Application by RWE Renewables UK Solar and Storage Limited for Tween Bridge Solar Farm Project
The Examining Authority's written questions and requests for information (ExQ1): Issued on 24 April 2026
Responses are due by deadline 2: 19 May 2026

Please find below answers to the Examining Authority's written questions from the Environment Agency (EA) [ref no. F1C2DDF91].

Appendix I – Proposed Raising in mAOD

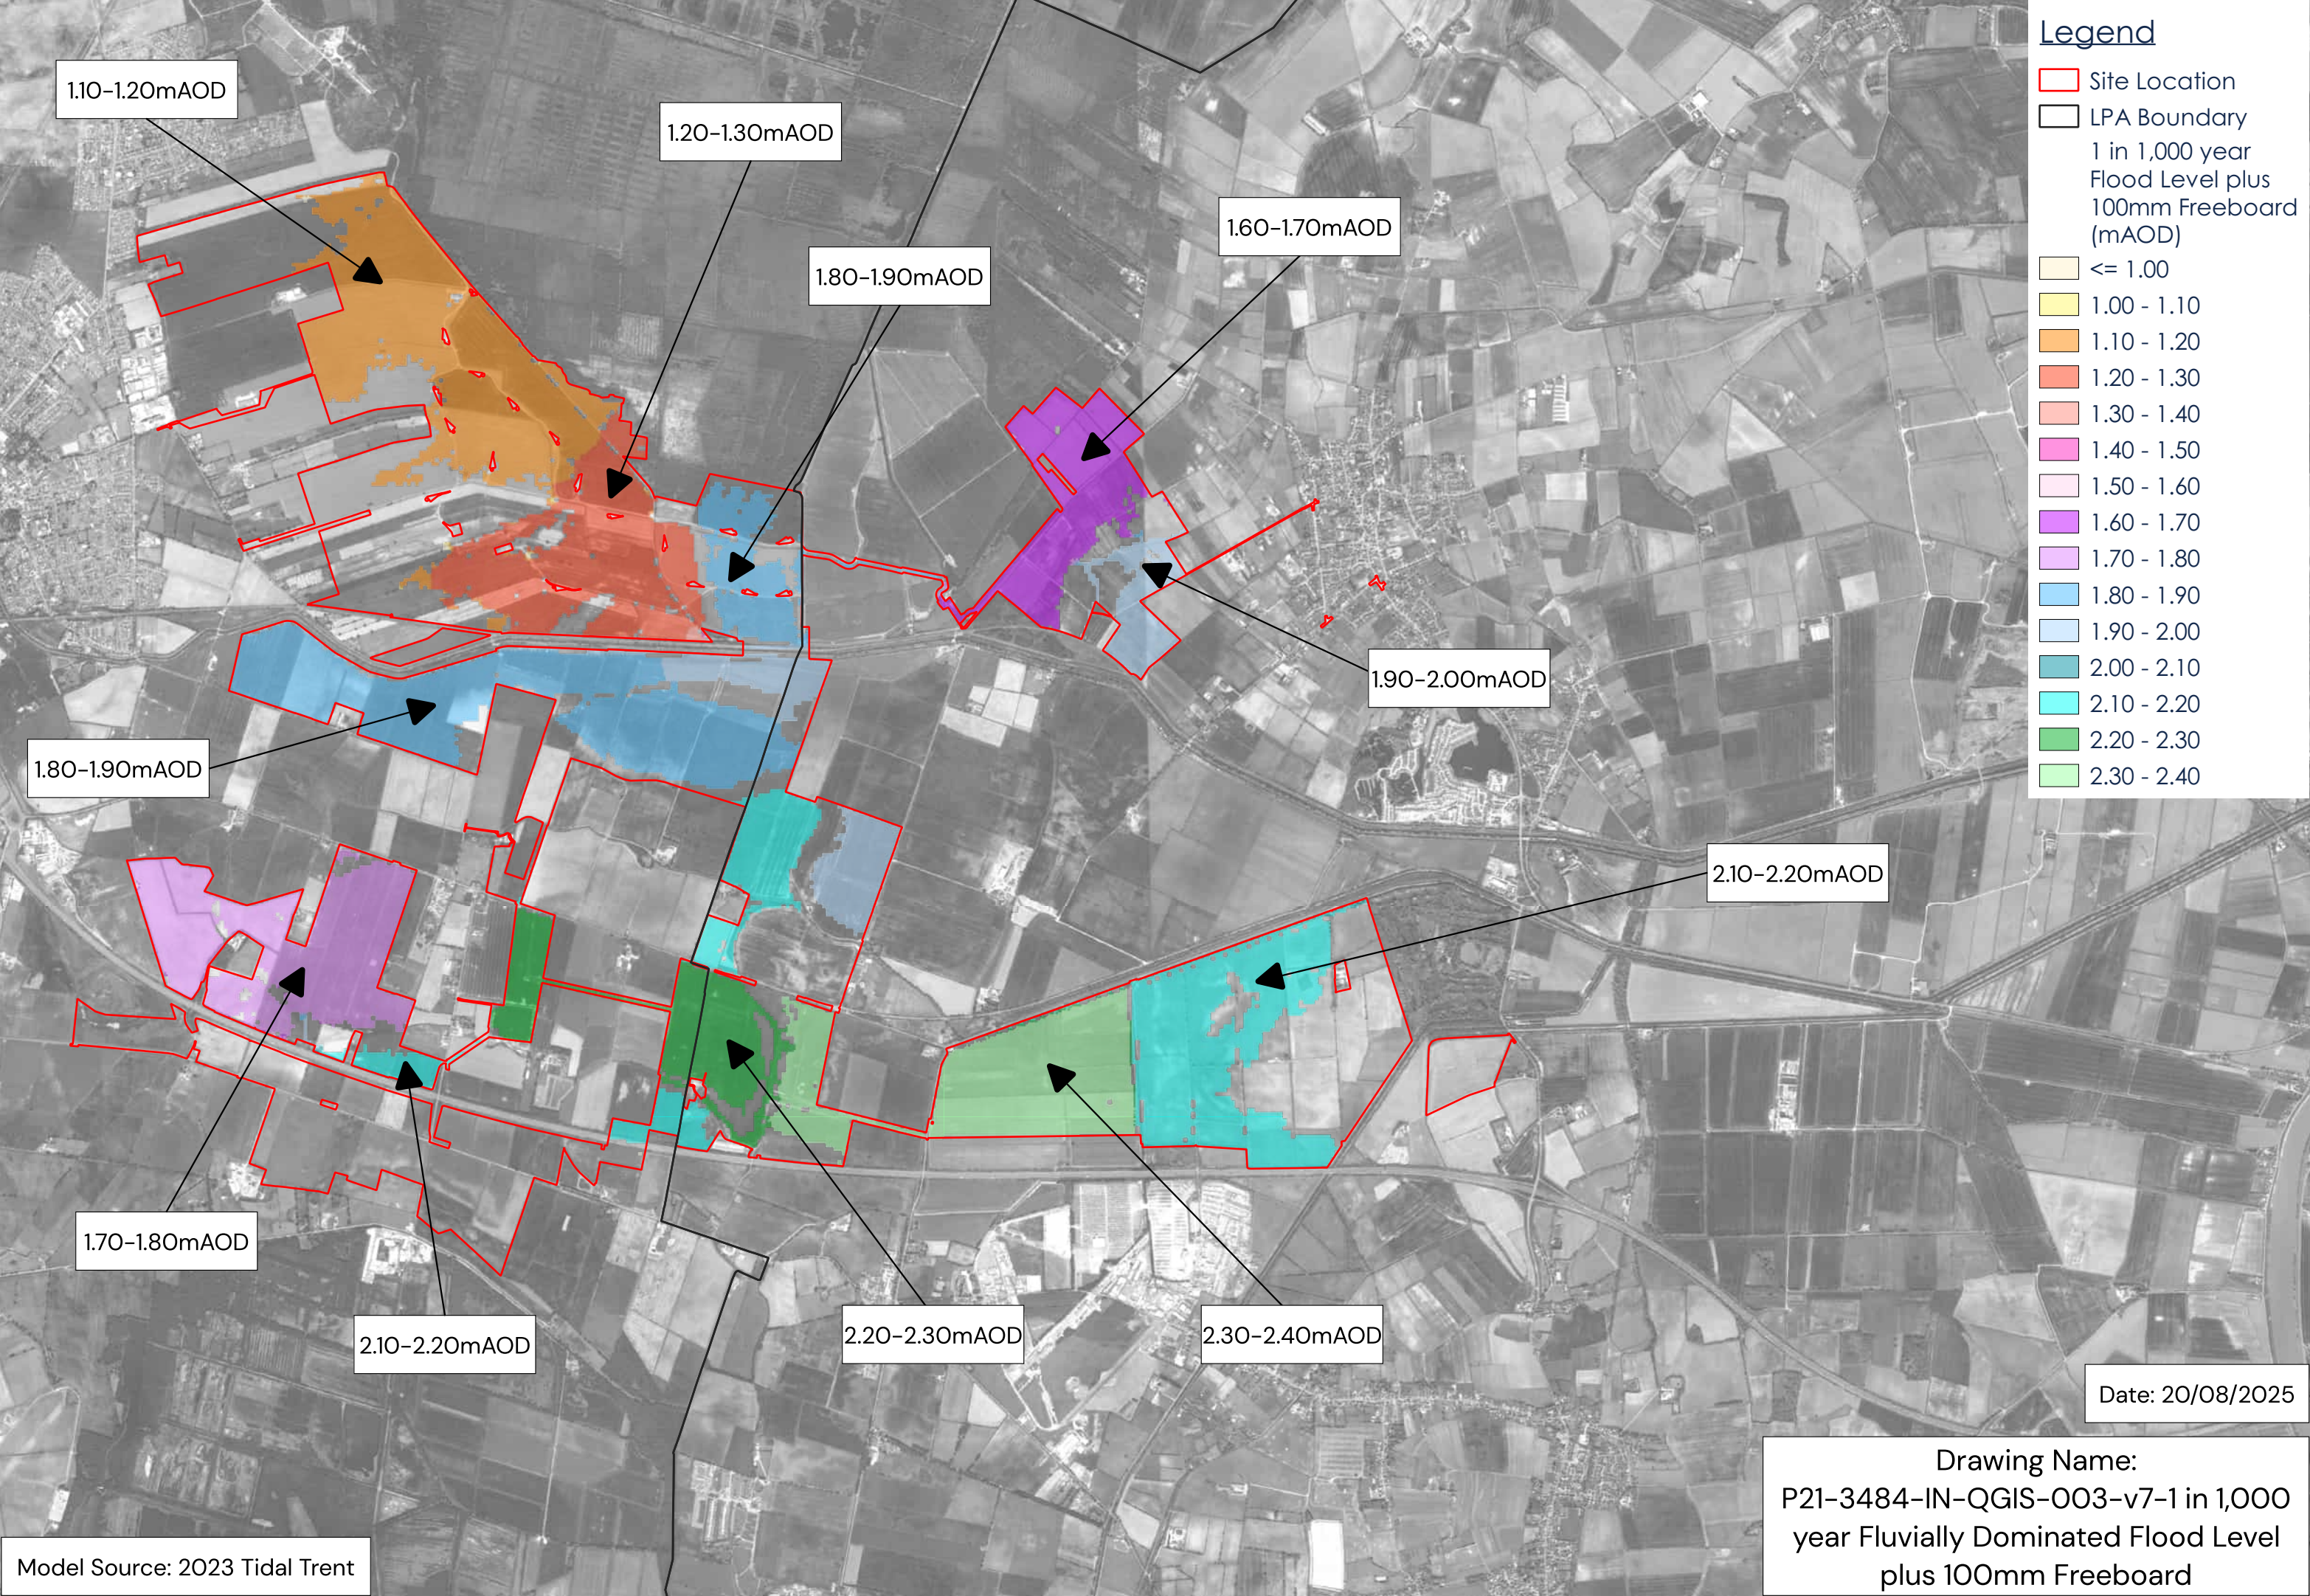
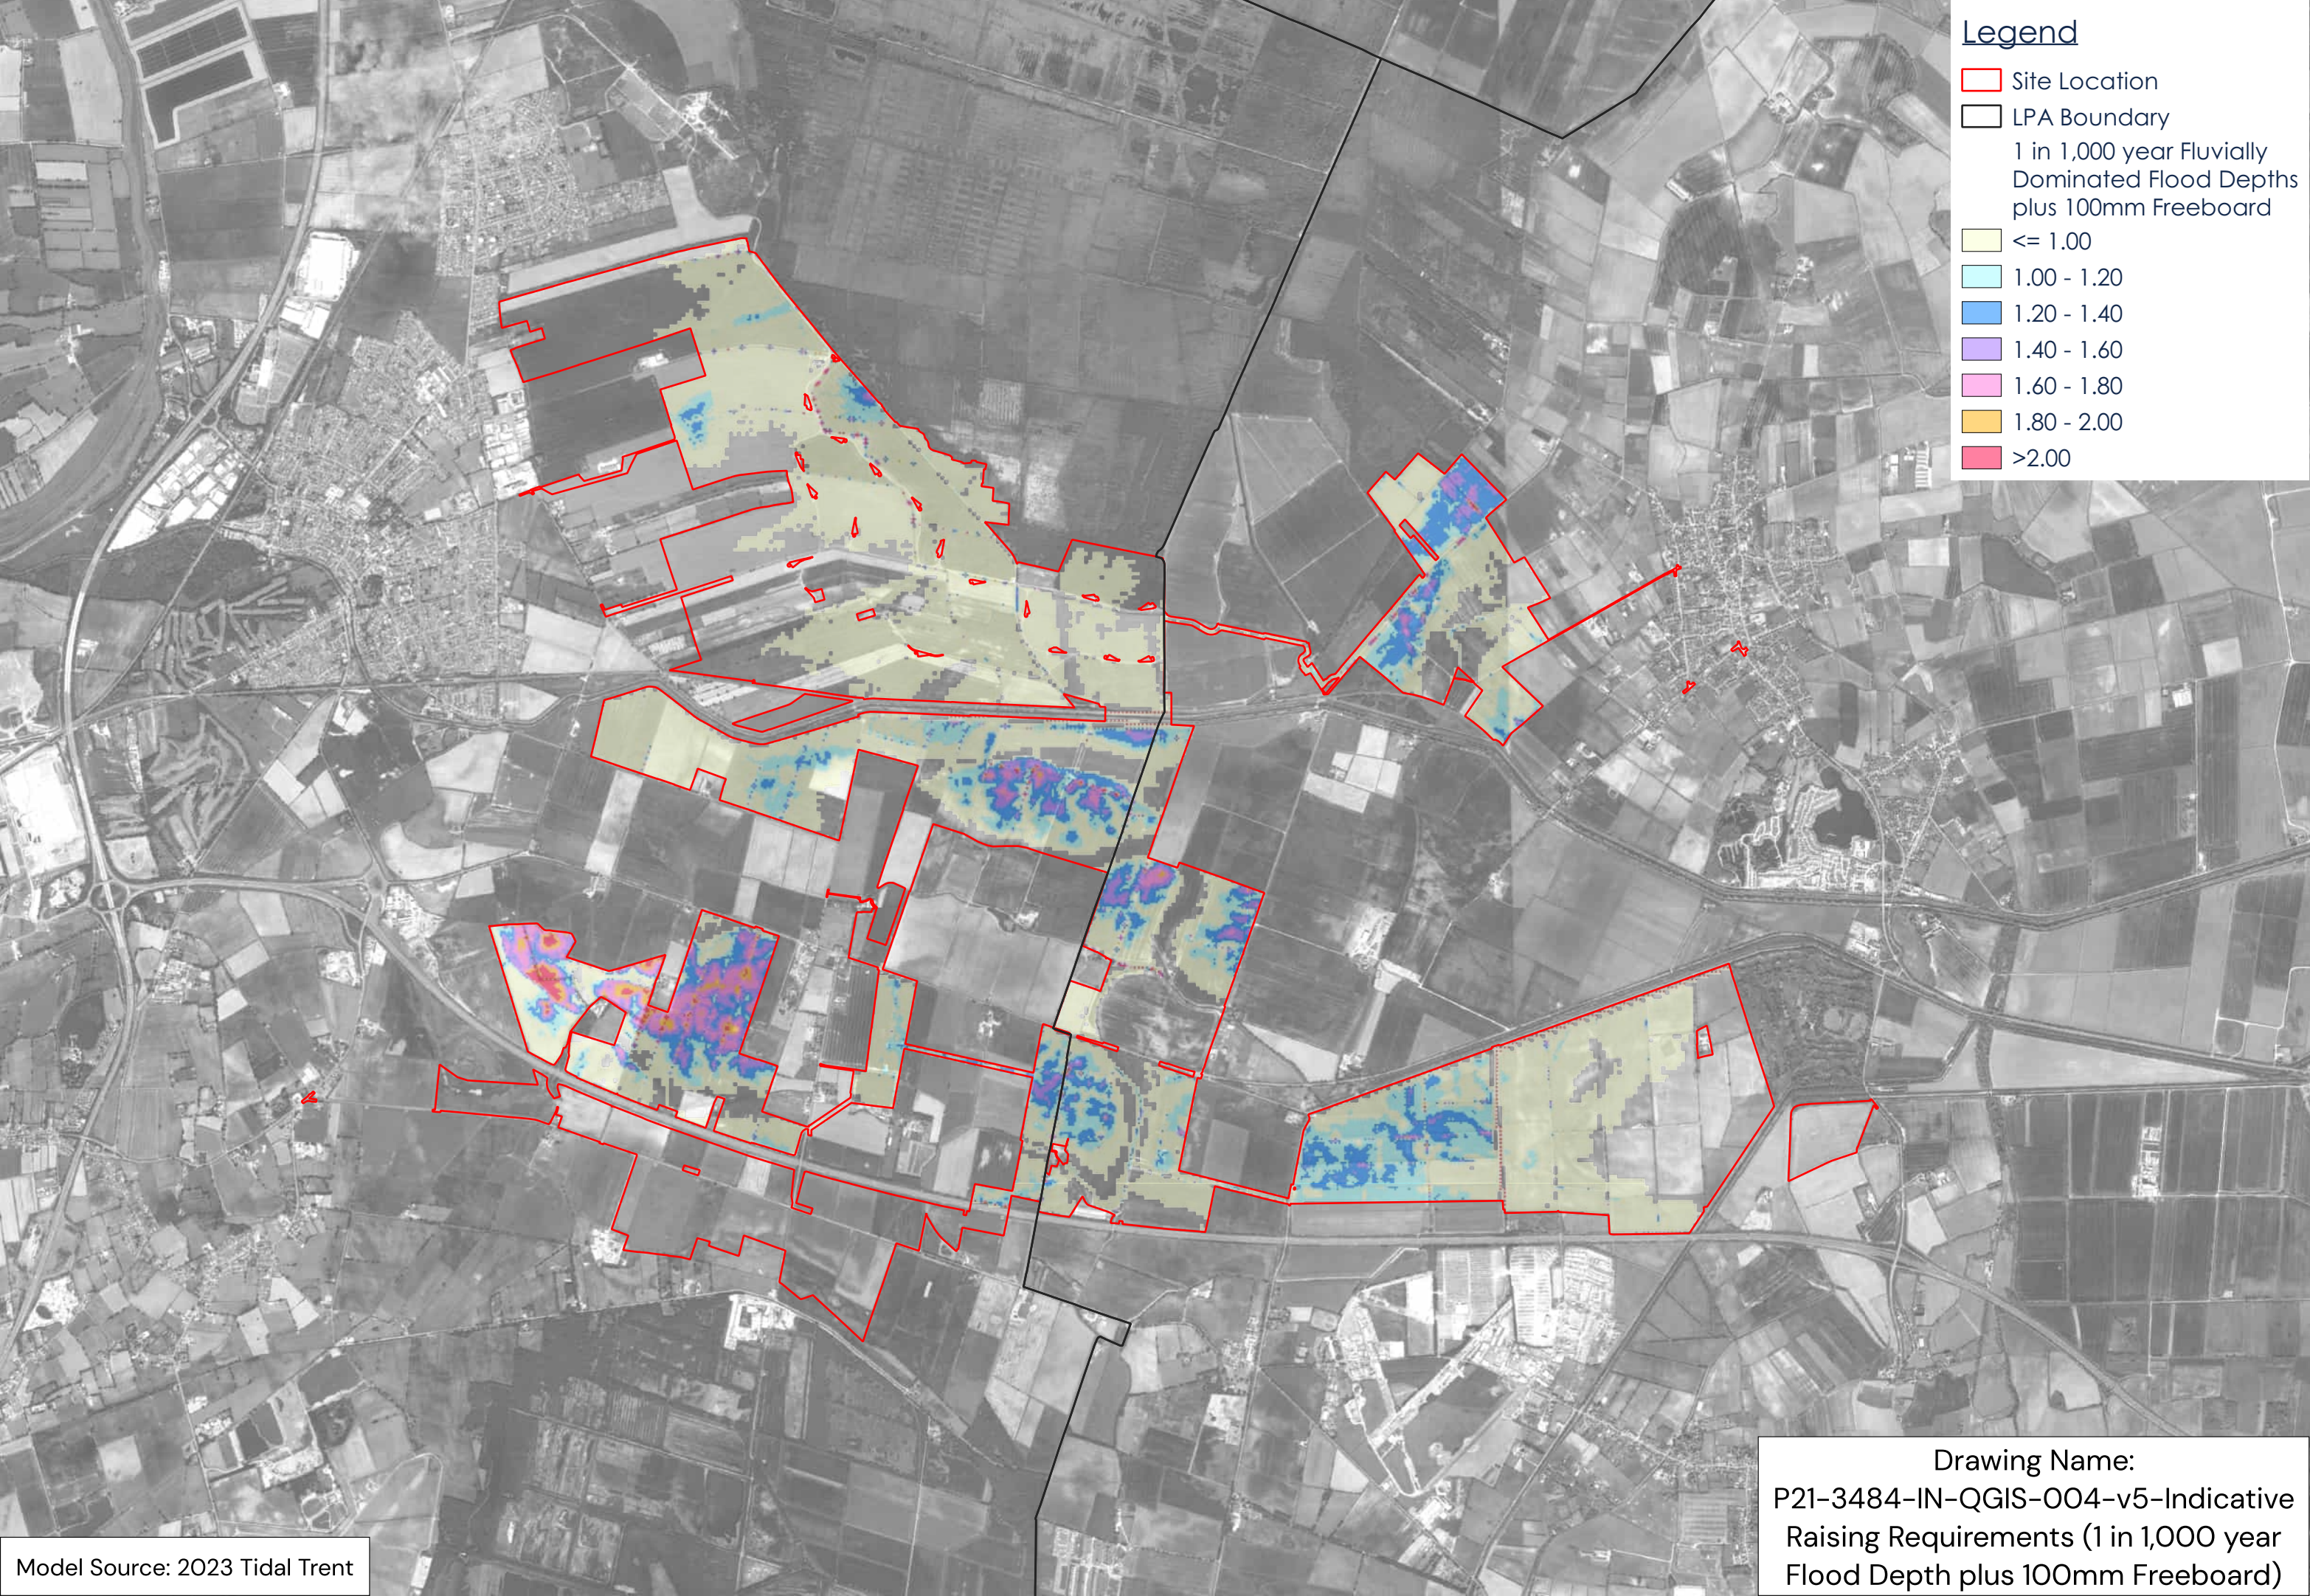
Ref No.	Question	EA response
	Please could the EA and Councils provide their views on this?	
Q7.0.34	<p>Use of climate change allowances: Paragraphs 5.9 and 5.24 of the FRA [APP-108] state that the 1 in 1000 year flood event has been used to assess the design of flood risk mitigation measures and represents a precautionary approach with a greater extent than the required 1 in 100 year plus climate change event for fluvial flooding and the required 1 in 200 year plus climate change event for tidal flooding. As such, no additional allowance for climate change has been included in the assessment beyond this.</p> <p>To all relevant IPs - please can you confirm if there are any comments you wish to make on the chosen climate change allowances?</p>	<p>The EA is satisfied with the approach to using the 1 in 1000 year flood event to inform the assessment of flood risk. The Trent 2023 1 in 1000 fluvial overtopping model shows greater flood extents and depths across the site compared to the 1 in 100 plus climate change (fluvial) or the 1 in 200 plus climate change (tidal) events. The 1 in 1000 event also indicates a greater flood extent and higher depths than the 1 in 100 plus climate change breach event. The EA is therefore satisfied with the approach taken on climate change allowances.</p>
